**CITY OF ALBUQUERQUE
PLANNING DEPARTMENT
June 24, 2015
DRB Comments**

ITEM # 11

PROJECT # 1008267

RE: Lots 6-8, Block 6, Santa Fe Addition

PLAT OF
 LOTS 6-A & 6-B, BLOCK 6 (SIX)
 PLAT OF THE
 SANTA FE ADDITION
 SITUATE WITHIN
 TOWN OF ALBUQUERQUE GRANT
 PROJ. SEC. 19, T10N., R3E., N.M.P.M.
 TO THE CITY OF
 ALBUQUERQUE
 BERNALILLO COUNTY, NEW MEXICO

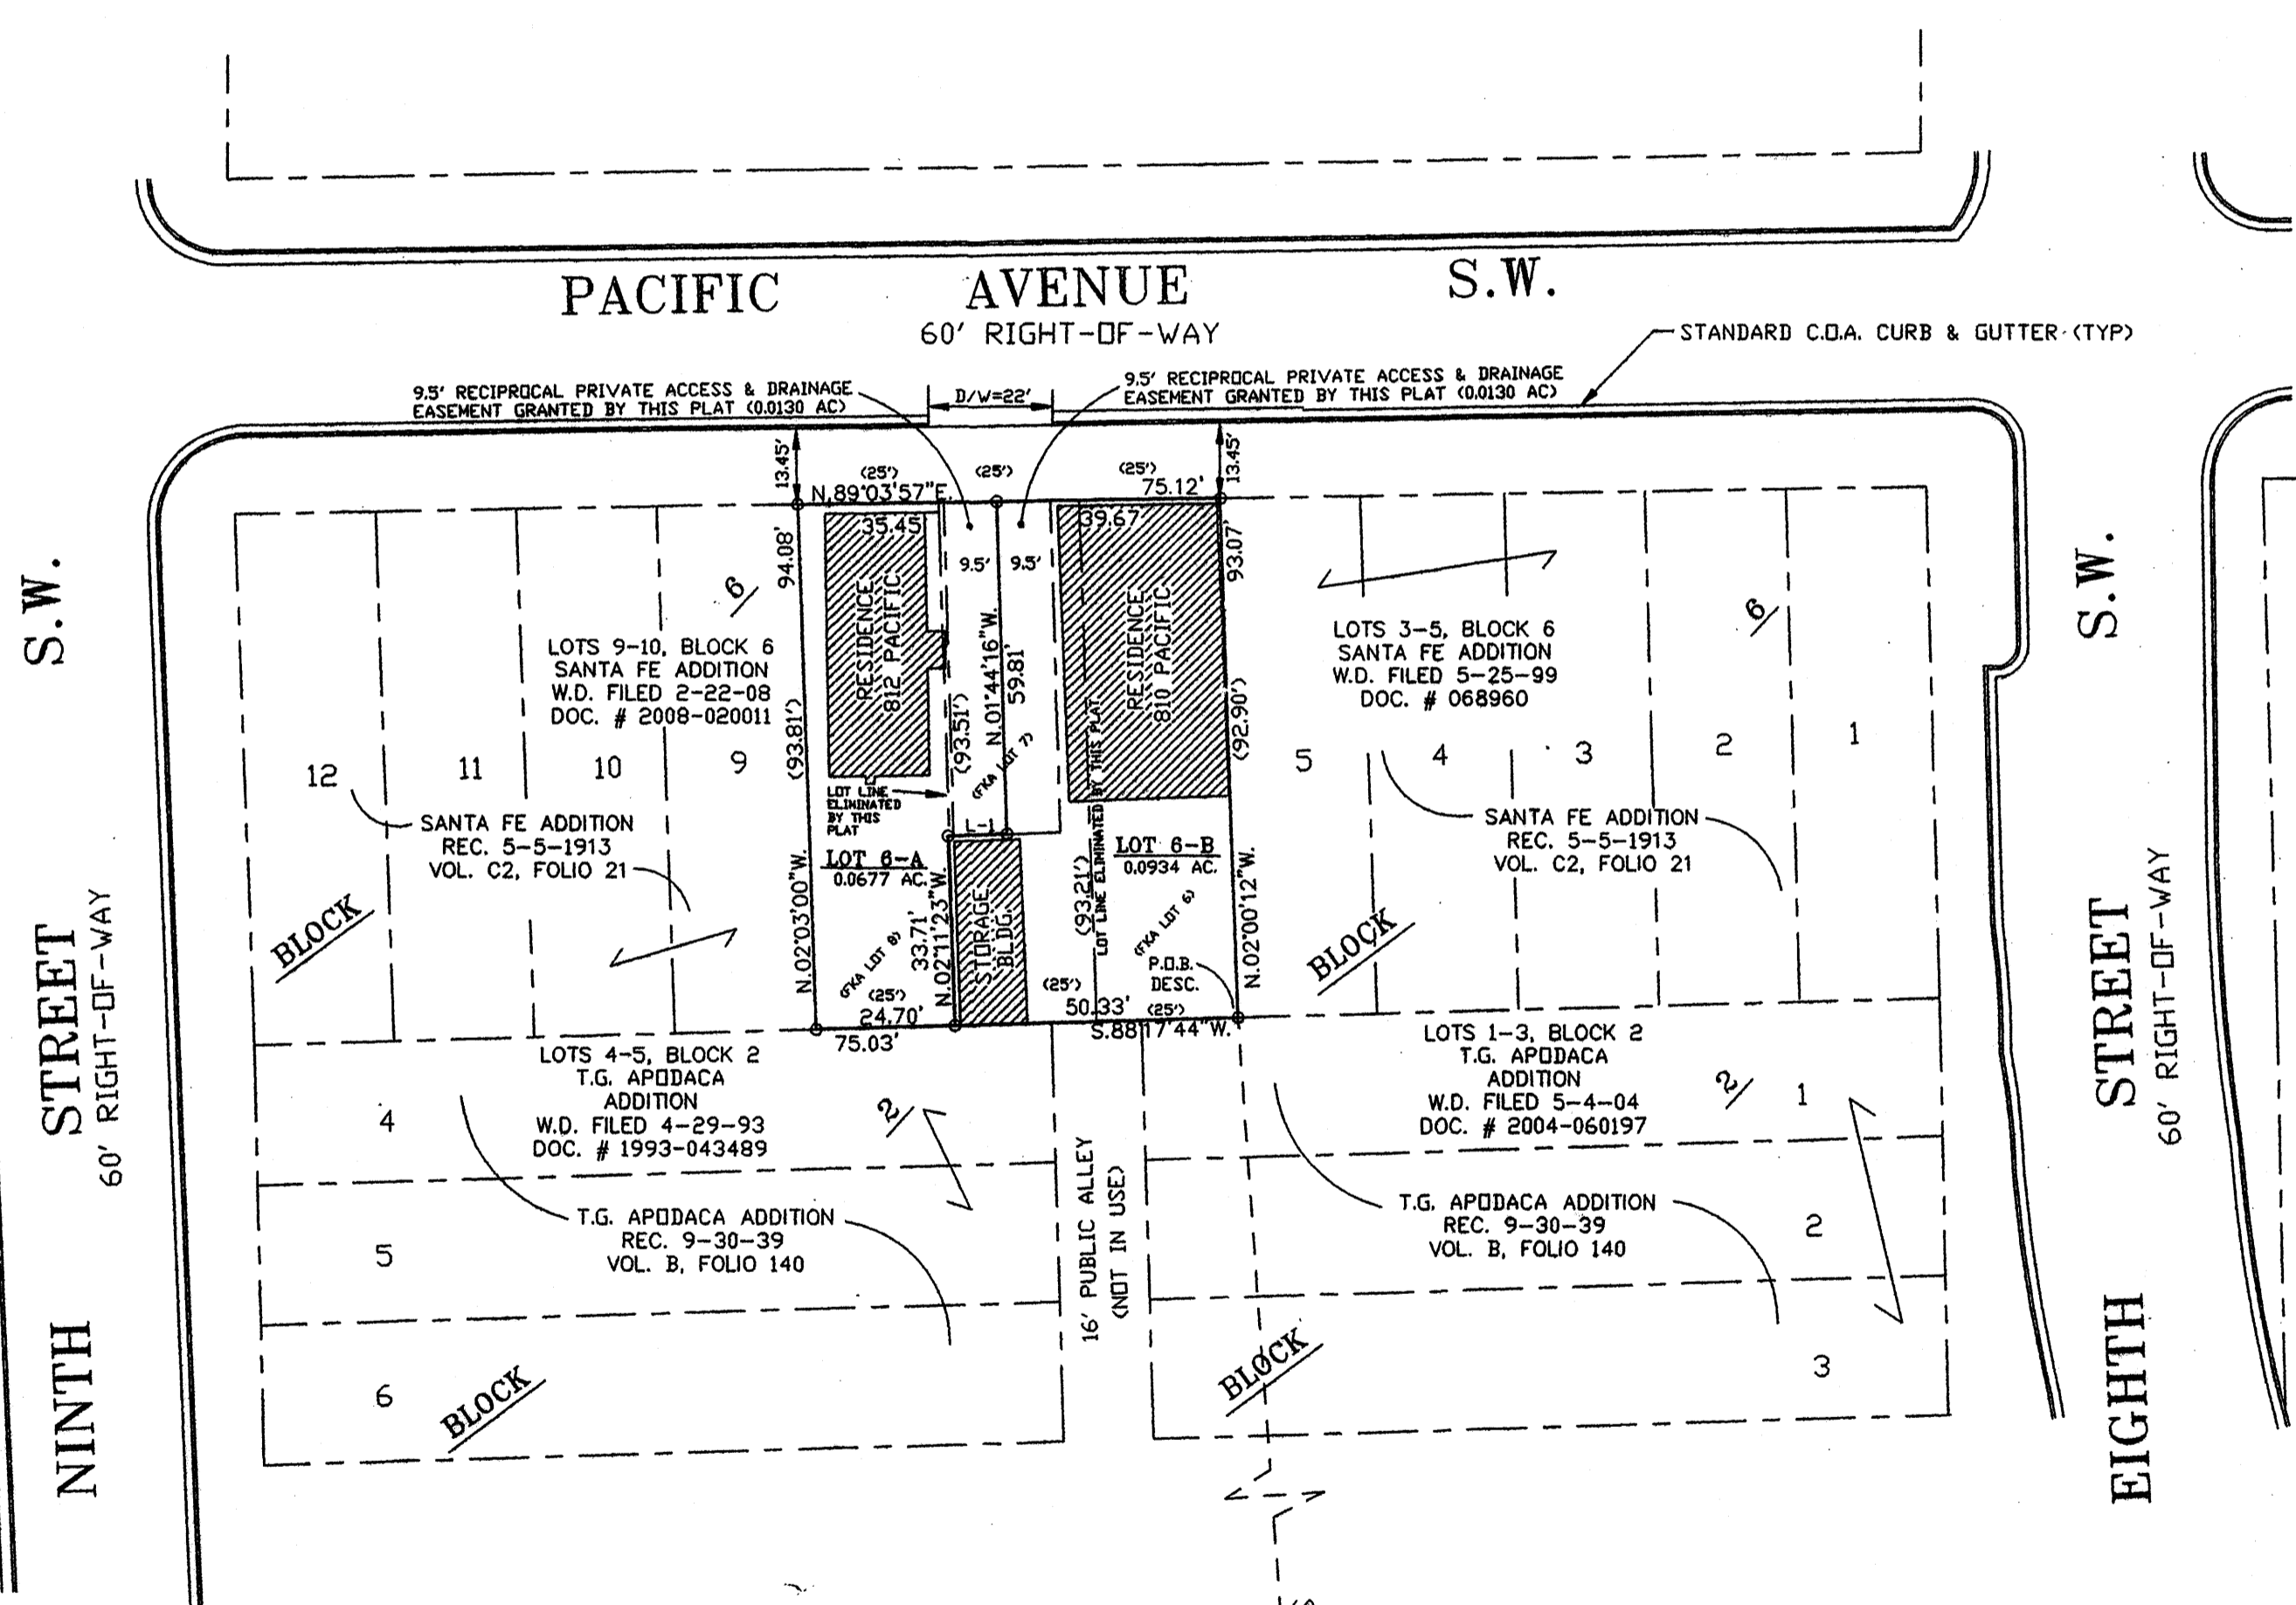
A reciprocal access and drainage easement would be needed on the proposed plat to cover the shared driveway area.
